# Hove Gardens, Hove Section 73 - Pre-App Report - NMA

July 2021  
CJCT  
Section 73 Report  
Planning Ref: BH2020/00917  
Rev 04

## Brief & Summary of Changes

Project:	Hove Gardens	Job No:	33031
Title:	PROPOSED SOUTH ELEVATION		
Scale:	1 : 200 @ A1	Drawn By:	ACK
Date:	JULY 2020	Checked by:	TR
Drawing No:	(20) 201	Revision	P.04

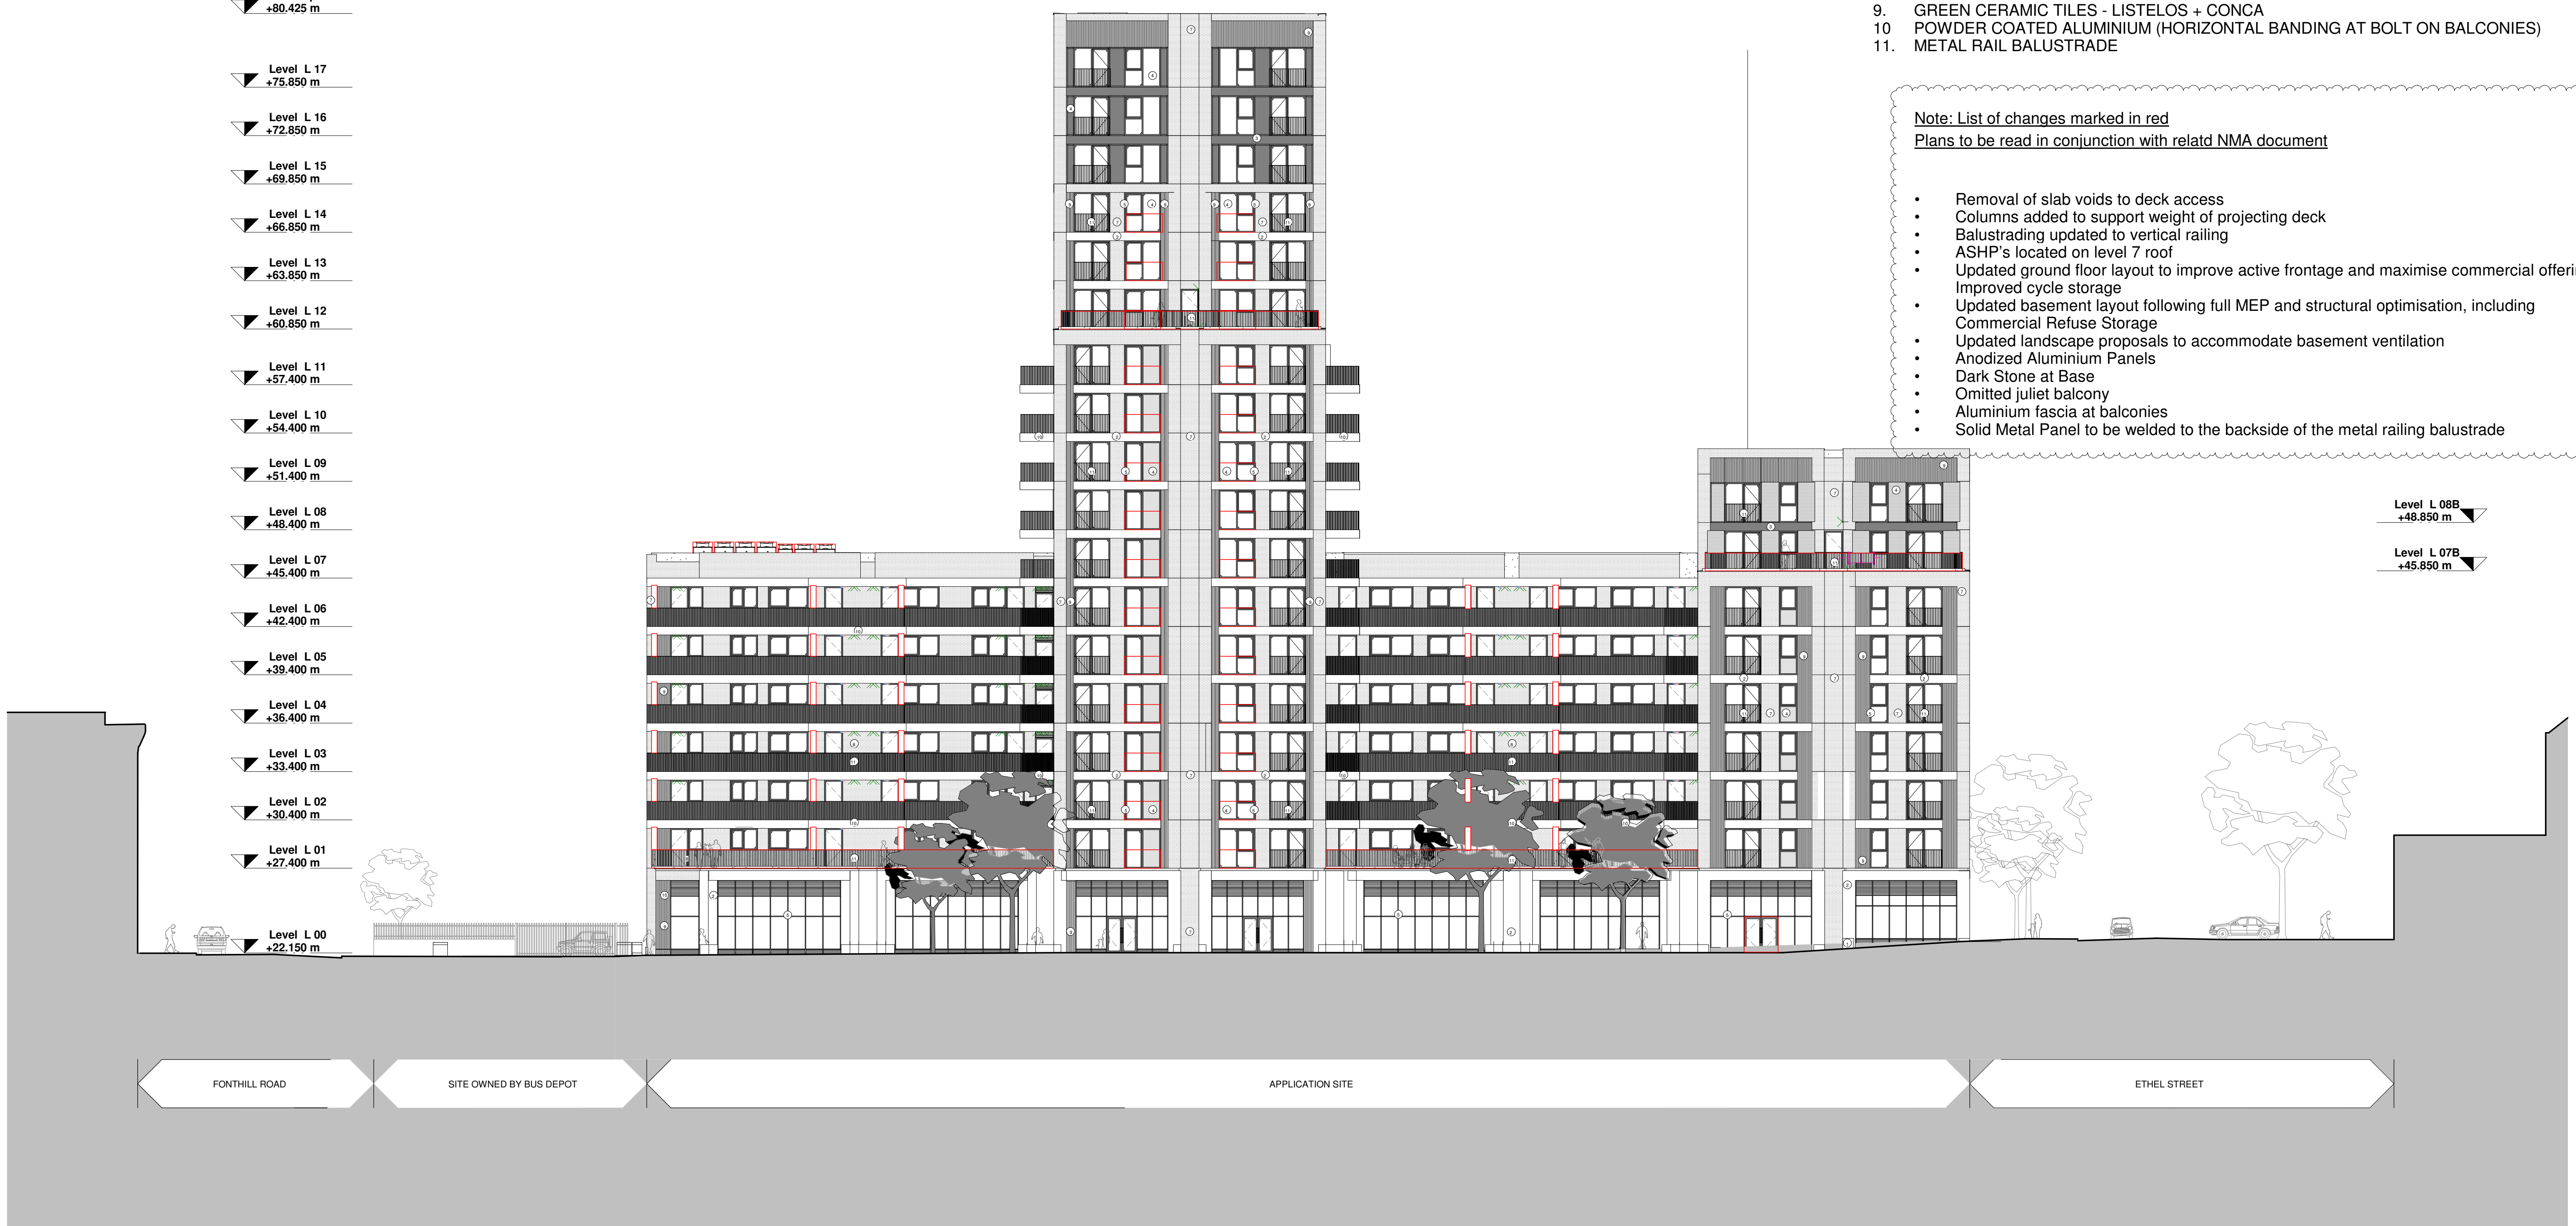
2.	Cantilevered deck access to dual aspect homes	Slab depth would be too thick and too much stress placed on the slab at the required width	Small columns to support deck access added to southern elevation

3.	Glazed screening at podium decks	Issue with attaining building insurance if glazing is used on roof terraces. There is a thin film which is placed between the two layers of glass which stops the glass from shattering at impact. On its own, this material can burn and as such, this is deemed not to be an A1/ A2 rated material which insurers don't like.	Glazed balustrading at roof terraces to be replaced with vertical metal railing to match that of the apartments

9.	Lighter stone cladding at GF Level	To prevent stains, wear and tear of the lighter stone.	Darker Stone band at base (GF Level)
10.	North Elevation Juliet balcony	To follow internal layout changes.	Omitted juliet balcony

11.	Stone Fascia	Aluminium coated to match lighter stone cladding. The aluminium fascia will only be used at bolt-on balconies to give the aesthetic appearance of stone and the aesthetic continuity between the balconies and the horizontal banding. This solution will also improve construction deliverability.	Powder Coated Aluminium Fascia at bolt-on balconies
12	Vertical metal railing at Deck Acces Balconies	To provide an imperforate walking surface at Deck Access Balconies, a Solid Metal Panel has to be welded to the backside of the metal railing balustrade. Fire Strategy requirement.	Solid Metal Panel to be welded to the backside of the metal railing balustrade
